Ref: DRA2500321

**BROADLANDS SOUTH WEST ROCKS
STATE SIGNIFICANT DEVELOPMENT (SSD-82352708)
PUBLIC AUTHORITY CONSULTATION – CASE ID (PAE-89572254)
286-310 GREGORY STREET SOUTH WEST ROCKS**

Figure 35. Post-development Stormwater Catchments (Source: King + Campbell, 2025)

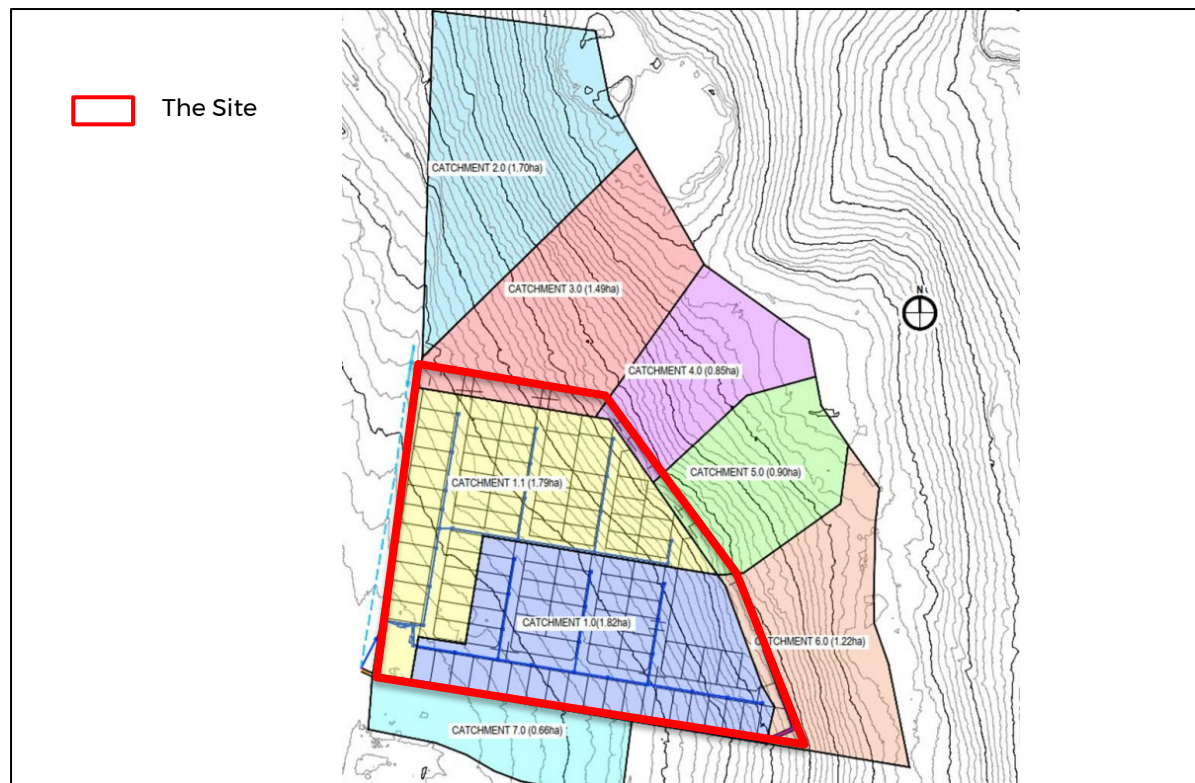
Without sufficient on-site detention (OSD) or staged outlet control for catchment 1.0 & 1.1, there's potential for short-duration peak flows to exceed minor system capacity and create nuisance flooding, even if 20%, 5%, 1% AEP targets are technically met. (D05.30, D05.36 Hastings council)

The SMP doesn't clearly show how these flows are separated from or integrated into the site's minor/major system without causing bypass or overloading.

The drawings show swales and pipes but do not clearly demonstrate safe conveyance of >1% AEP flows without property inundation.
